CROWN STREET DEVELOPMENT APPLICATION
SUMMARY OF SUBMISSIONS

- LEGEND**
- ITEM 2
RELOCATION OF THE WESTERN FACADE ON DWYER'S SITE
 - ITEM 4(a)
PROPOSED WIDENING ALONG THE WESTERN BOUNDARY
AND PROVISION FOR A PEDESTRIAN PATH

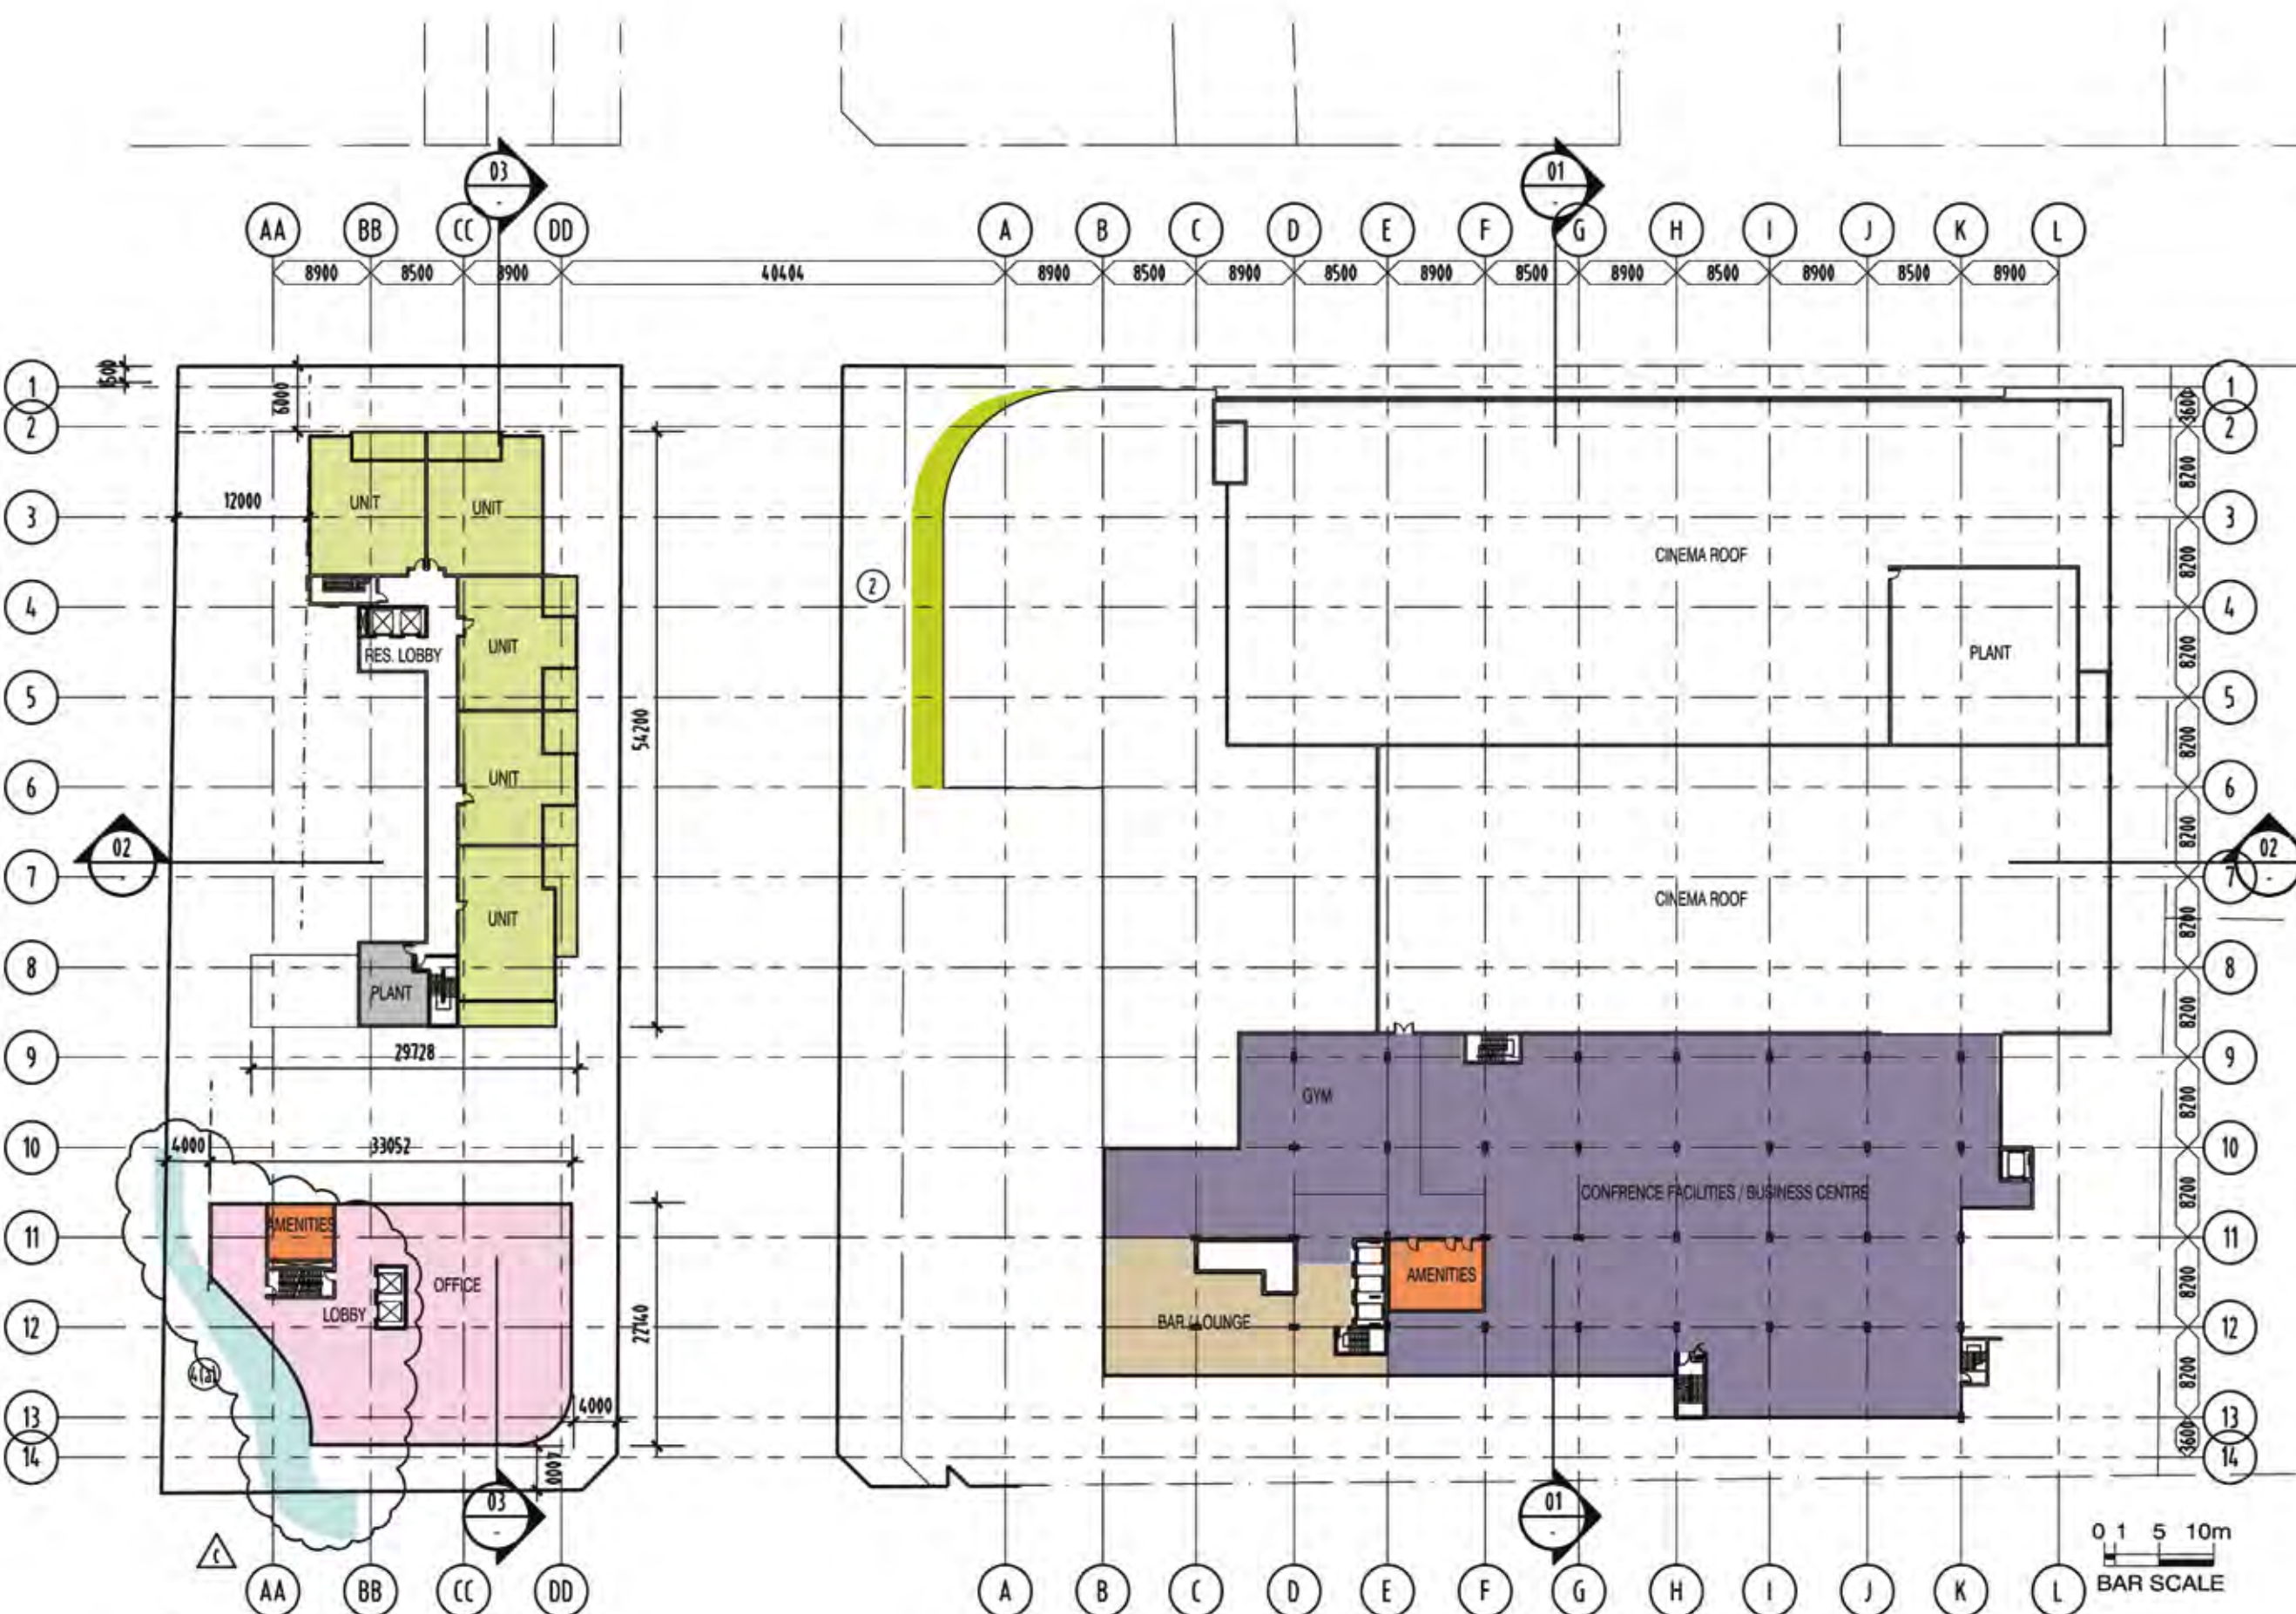
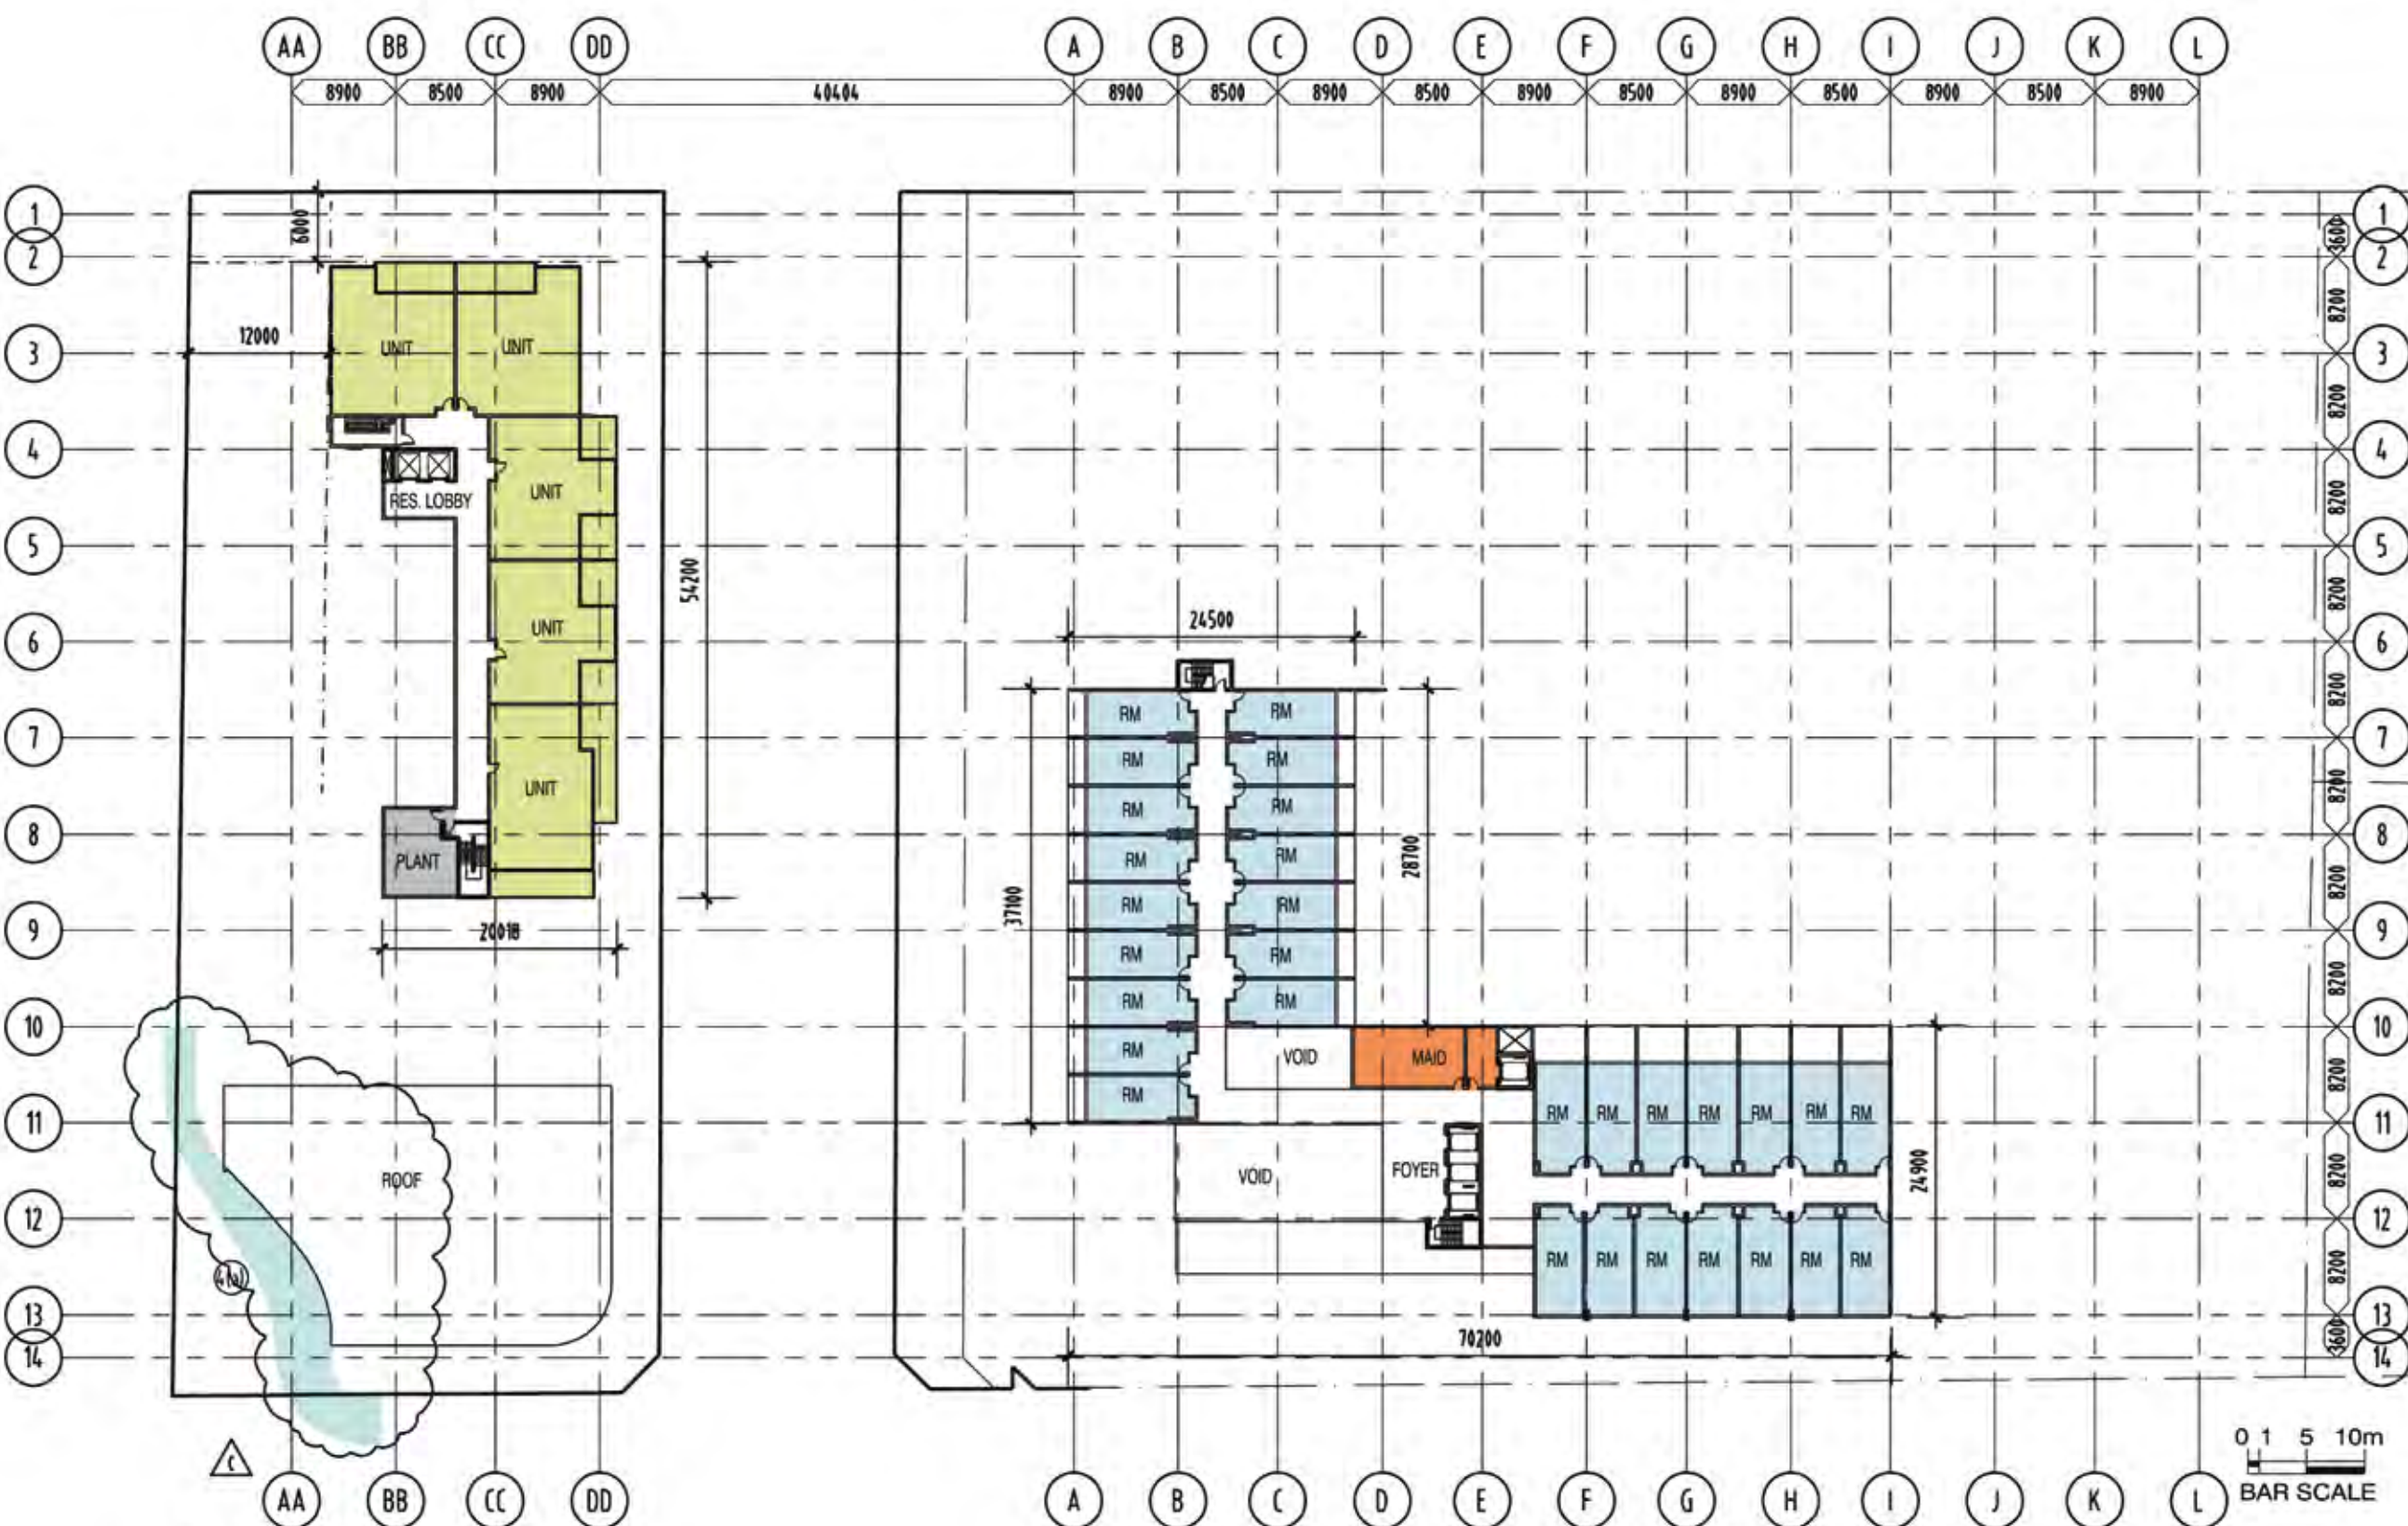
Ref No.	Submitter	Issue	Comment	Recommended Action
		6.2 Proposal is inconsistent with road widening reservations. • Proposal for Dwyer's site encroaches on road reserve along Corrimal Street – amended plans required to include setback. • Oxford site shall be redesigned to allow for road widening in accordance with WCC Infrastructure Division's Dwg No. 4268, 01/08.	Amendments have been made to address the proposed road widening of Corrimal Street. See also address in Urbis covering letter. As also addressed in the Urbis letter, it is considered onerous for Council to require further road widening of Town Hall Place.
